DOC19/544951
SSI 7308

27 June 2019

EIS for St Marys Intermodal (St Mary's Freight Hub) - Request for EPA Comment

I refer to the request from the Department of Planning and Environment (DPE) to the NSW Environment Protection Authority (EPA) dated 28 May 2019 to undertake a review of the Environmental Impact Statement (EIS) for the proposed St Marys Intermodal project SSI 7308.

FIGURE 4 CONTAINER FREIGHT FLOW CHART

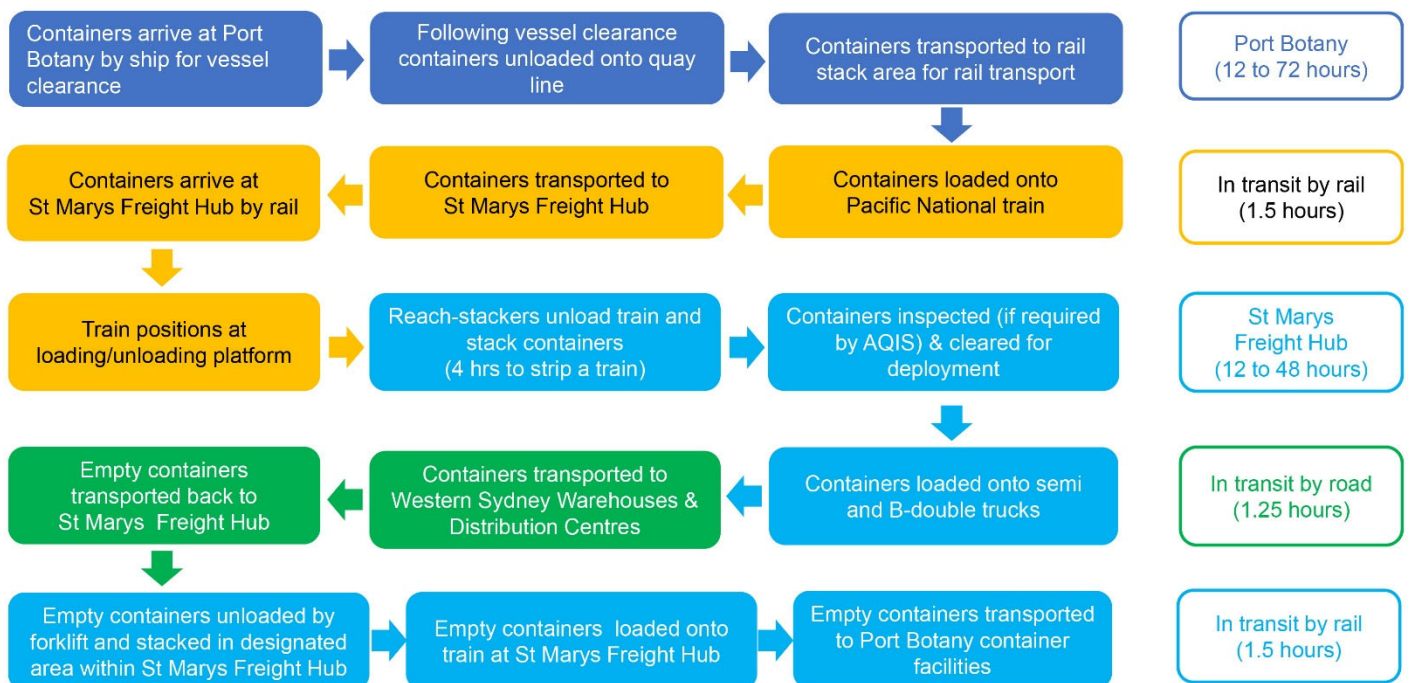
The container freight flow chart in Figure 9 of the EIS report shows that there will be multiple operating scenarios and activities to take place across the site. The EPA is concerned that using

only one scenario to assess all of these activities is not sufficient to identify and quantify potential noise impacts from all activities and operations occurring across the site. This also has limited the ability to evaluate all potential mitigation measures. The proponent should provide justification that the various activities that will take place on the site are sufficiently captured by the single assessed scenario and how mitigation has been assessed and designed using a single scenario. Alternatively, the proponent must assess all relevant scenarios and update their assessment.

Construction Noise Contour Plots

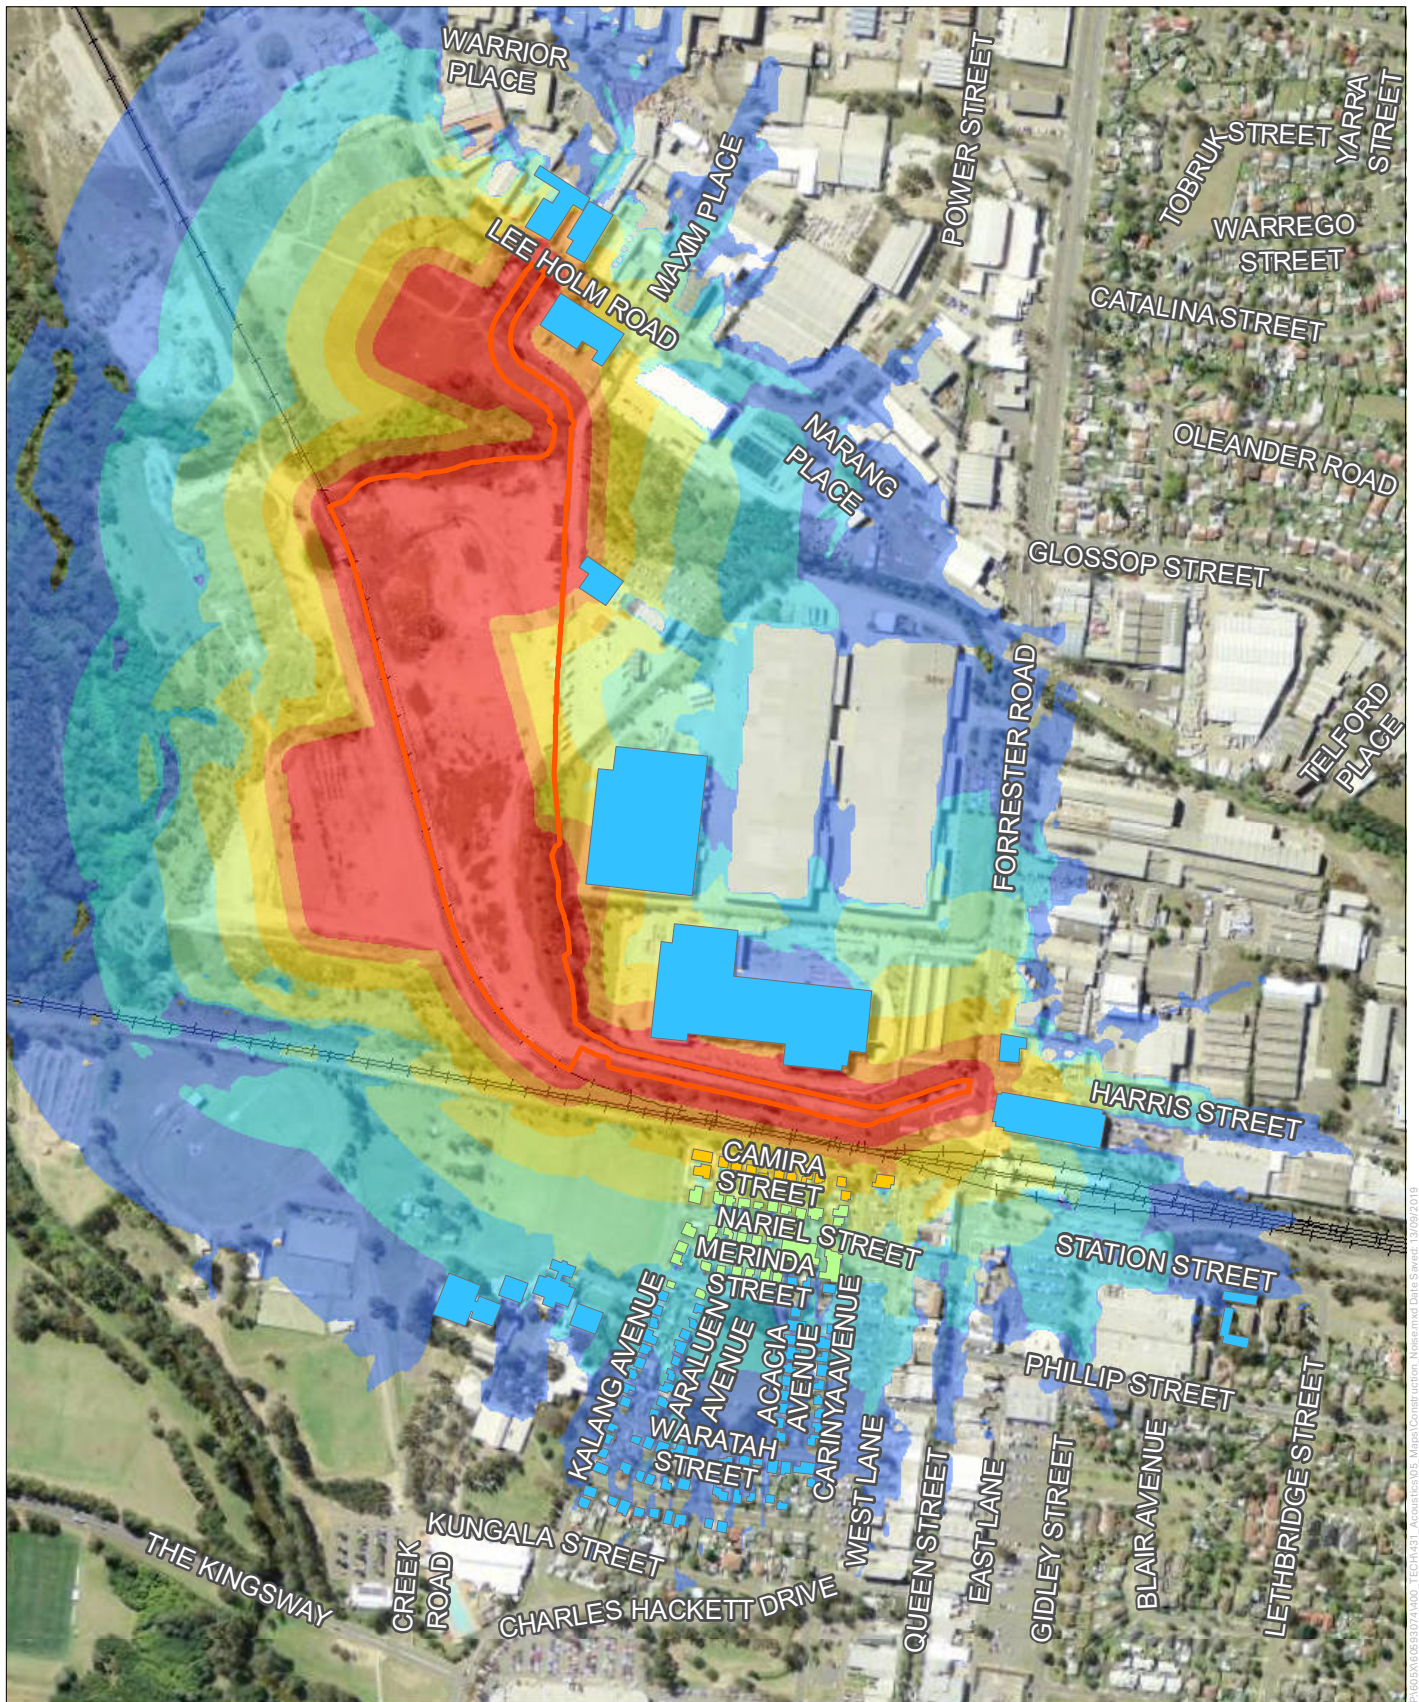
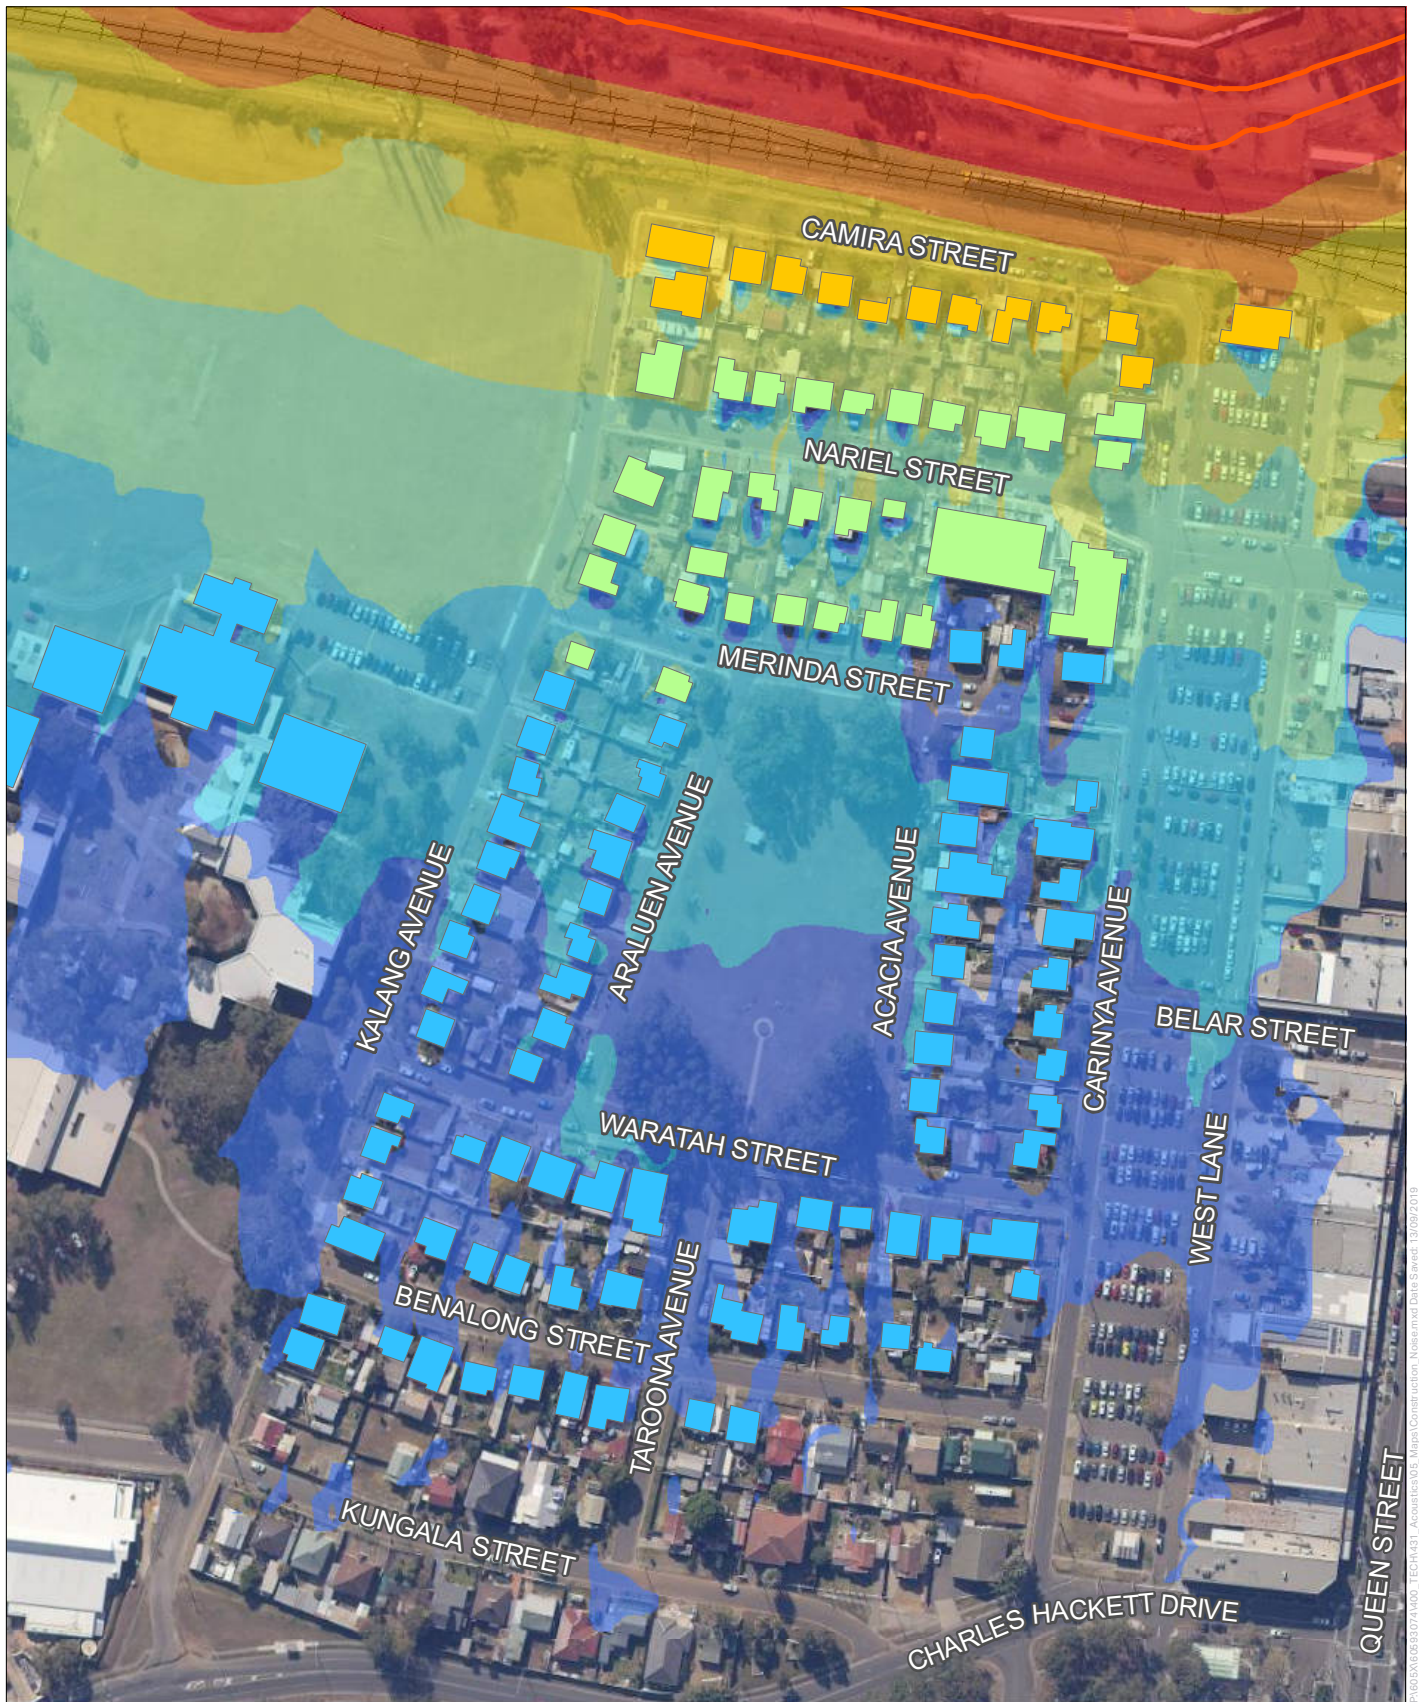
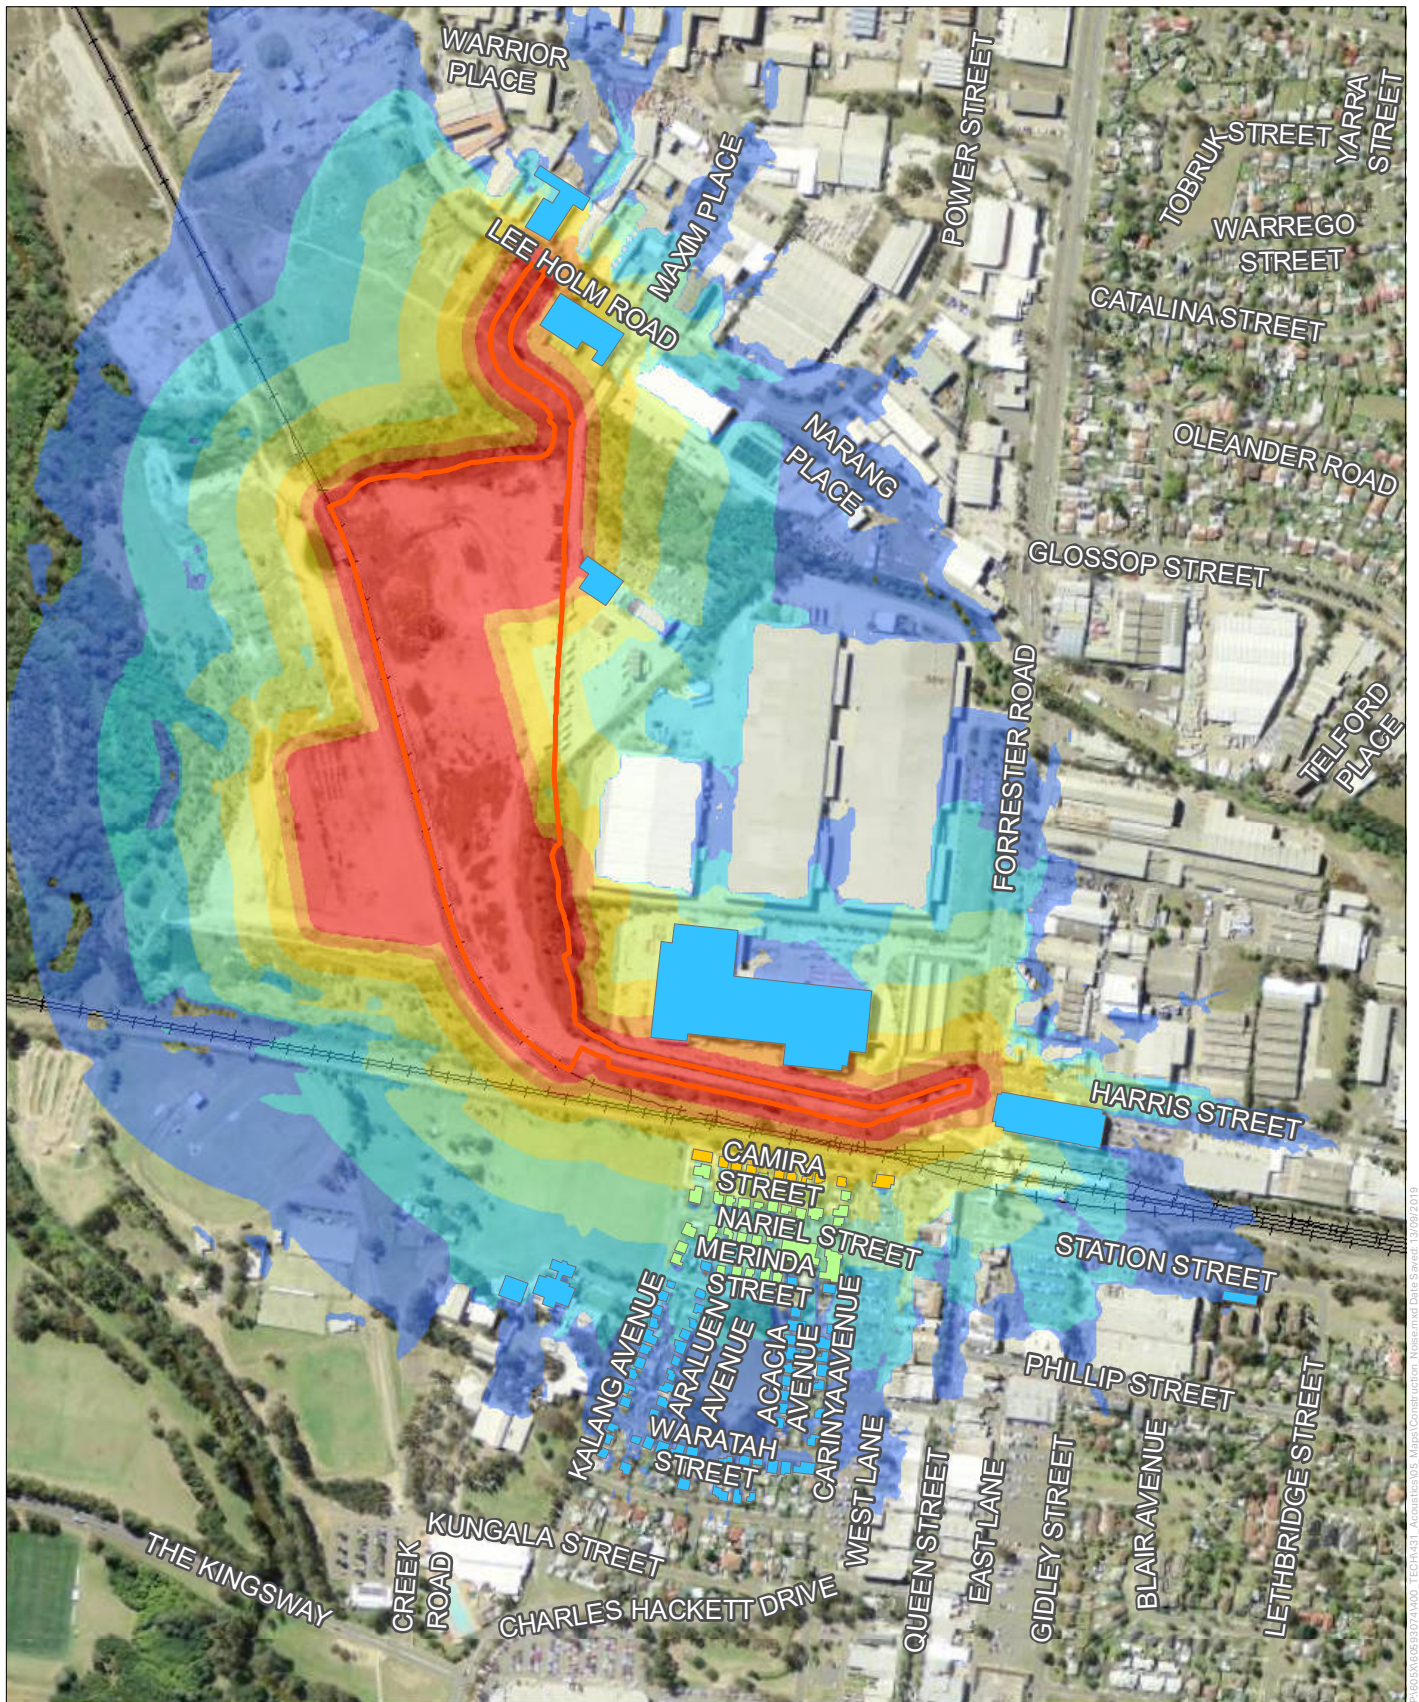
1. Maps in Appendix C of the noise report use highlighted buildings to identify impacted receivers. However, buildings are obscured by the road names. The maps should be updated so that individual buildings can be more easily identified.
2. Section 5.4.1 of the noise report gives a summary of the number affected above the NML, however it does not differentiate between residential and other receiver types. The report should provide a clear indication of the impacts in each NCA and the receiver types for each work package.
3. Construction must to be limited to standard hours:
7am to 6pm Monday to Fridays
8am to 1pm Saturdays
No work Sundays and Public Holidays
4. A construction noise and vibration management plan should be used to manage construction impacts in accordance with the Interim Construction Noise Guideline (DECCW, 2011)
